PLANNING AMENDMENT

APPLICANT NAME AND ADDRESS IAN BUCKLEY 145, BOURNE ROAD SPALDING PE11 3LJ Telephone: [REDACTED]		AGENT NAME AND ADDRESS DEREK BUCKLEY 20 CHURCHFIELDS AUDENSHAW MANCHESTER M34 5HZ Telephone: 07525 143 171	
SITE ADDRESS DETAILS 145, BOURNE ROAD, SPALDING. PE11 3LJ.			
CURRENT APPLICATION NO: This amendment cannot be considered unless the relevant reference is stated.		H16-0803-21	
Building Regulation reference relating to same development (if applicable)		N/A

2 STOREY FRONT EXTENSION
AND SINGLE STOREY REAR
AND FIRST FLOOR SIDE
EXTENSION AND LOFT

CONVERSION WITH REAR
DORMER INC. ROOF
RE-DESIGN, DETACHED
GARAGE AND REPLACE
SEPTIC TANK

21/DB/003

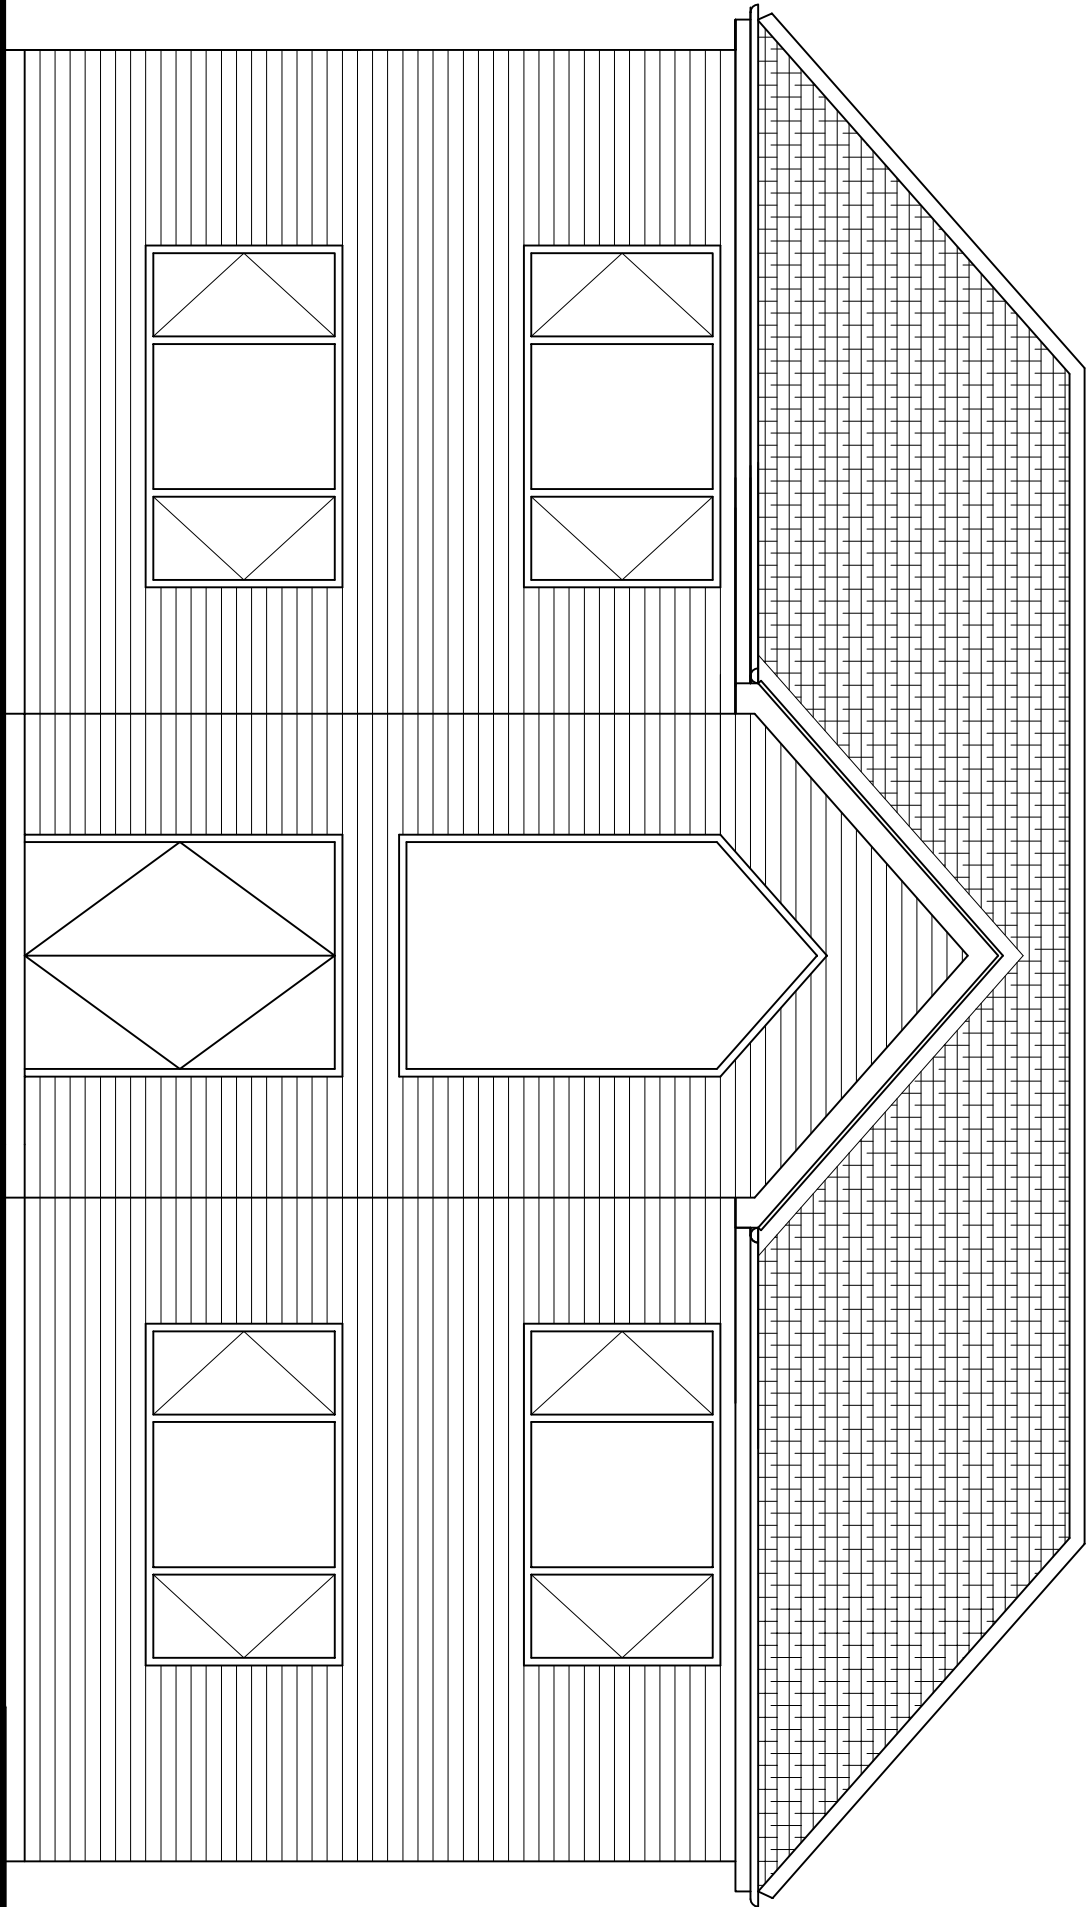
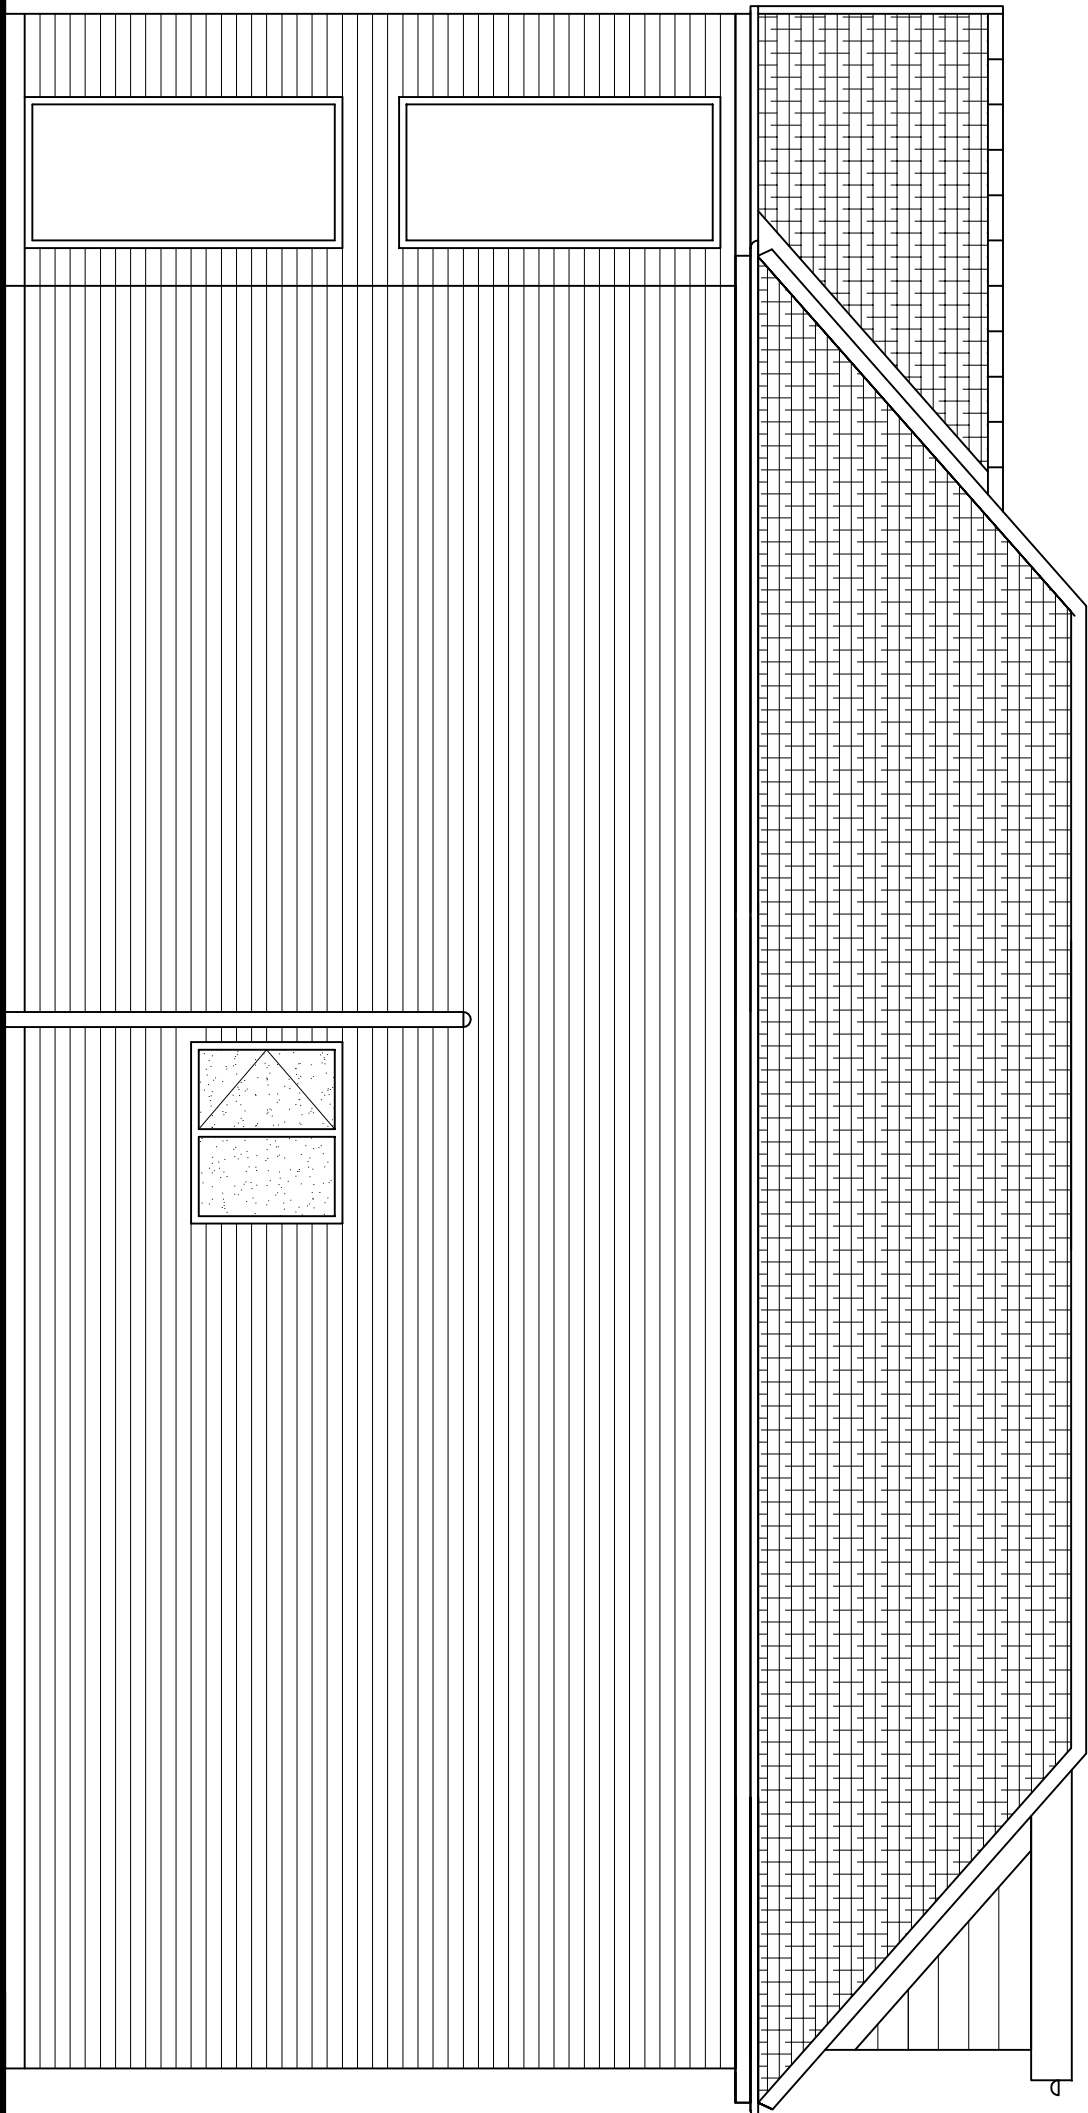
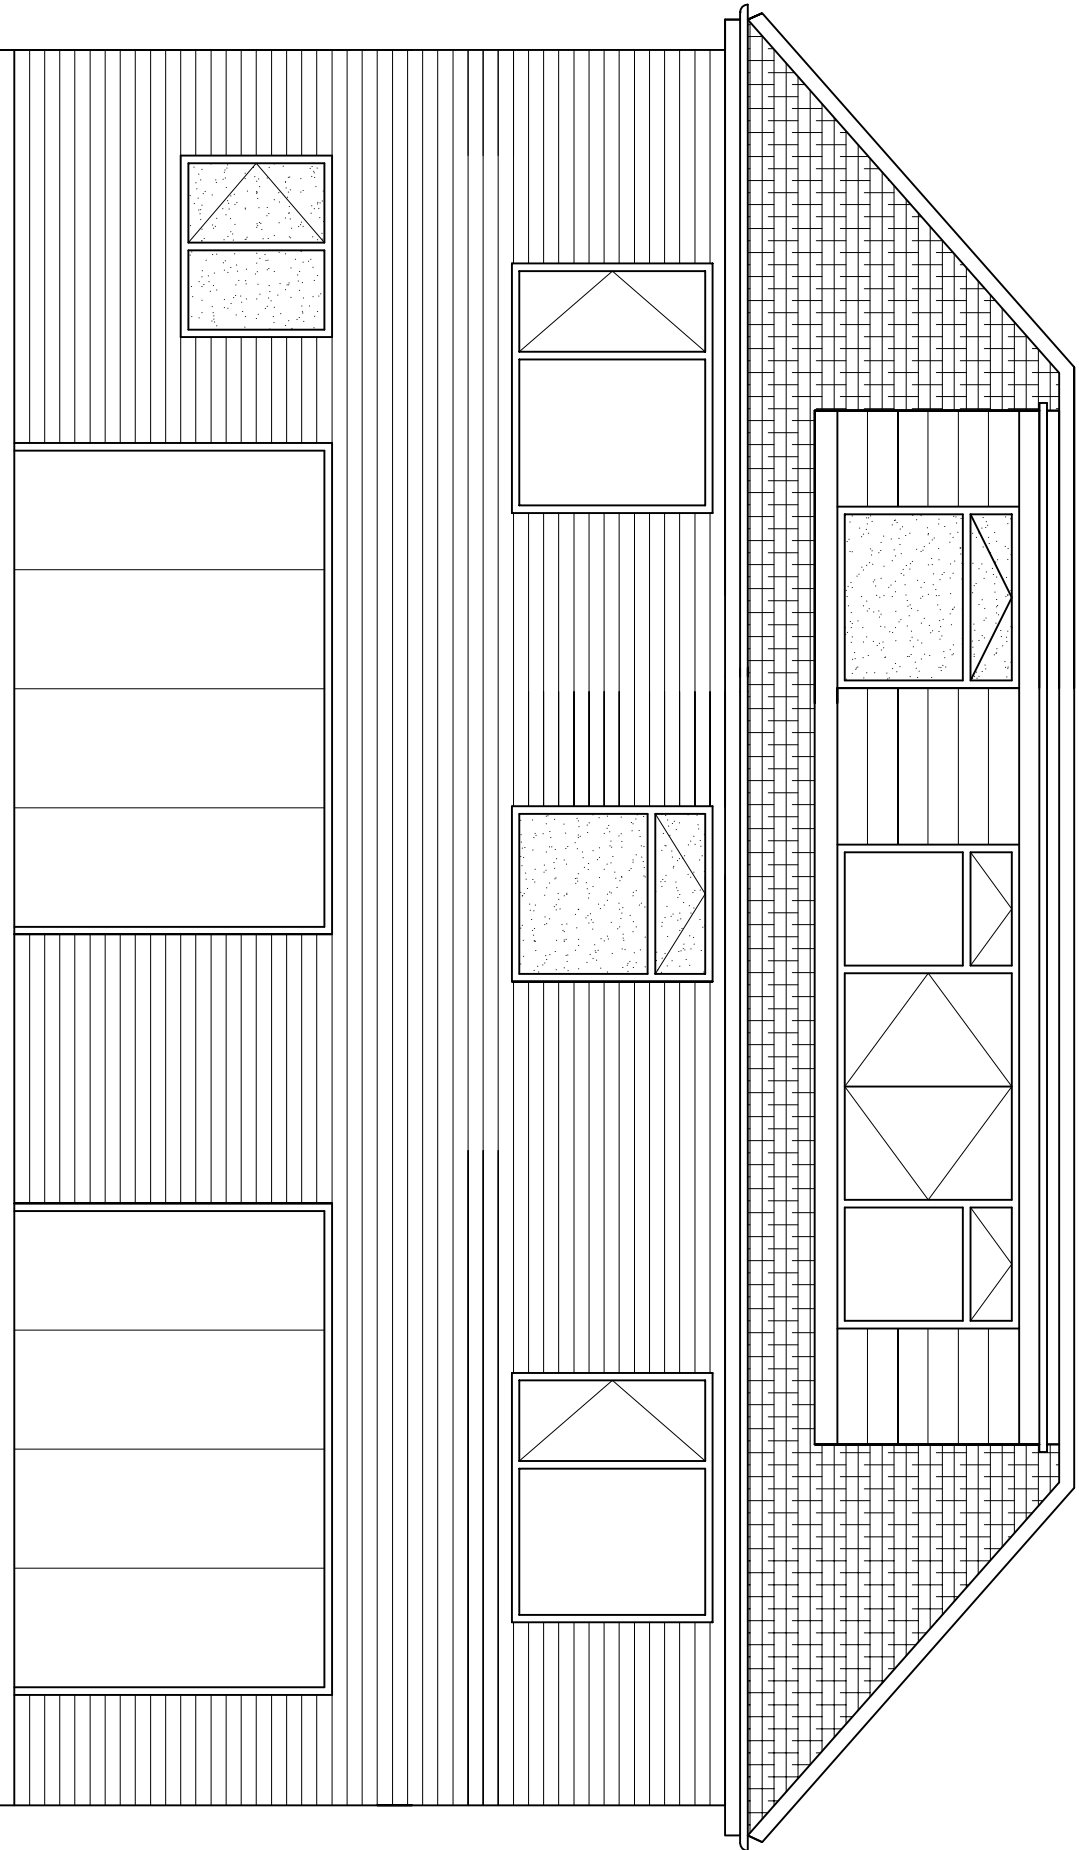
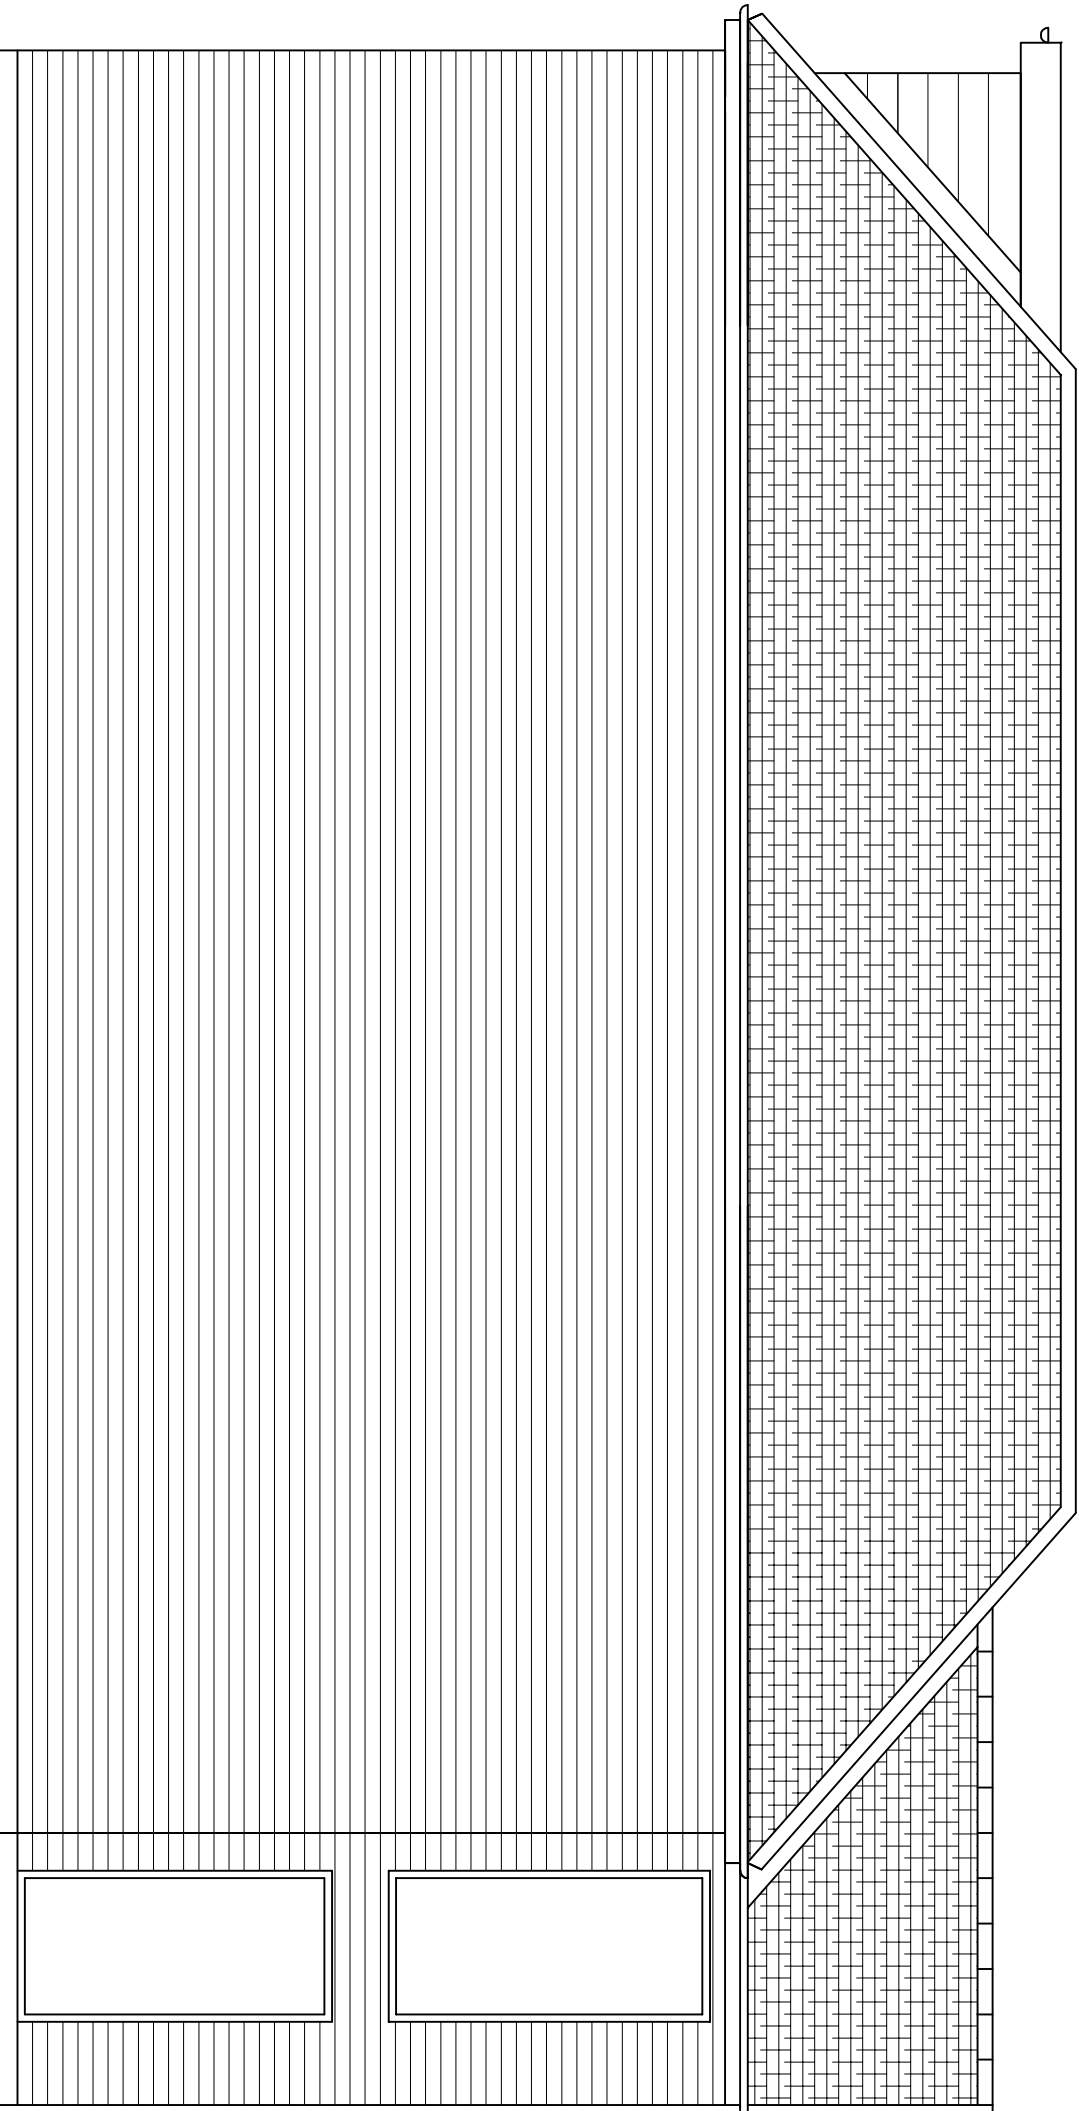
→ AMENDMENT : REAR EXTENSION TO BE 2 STOREY.
INCREASE IN ROOF SPACE.
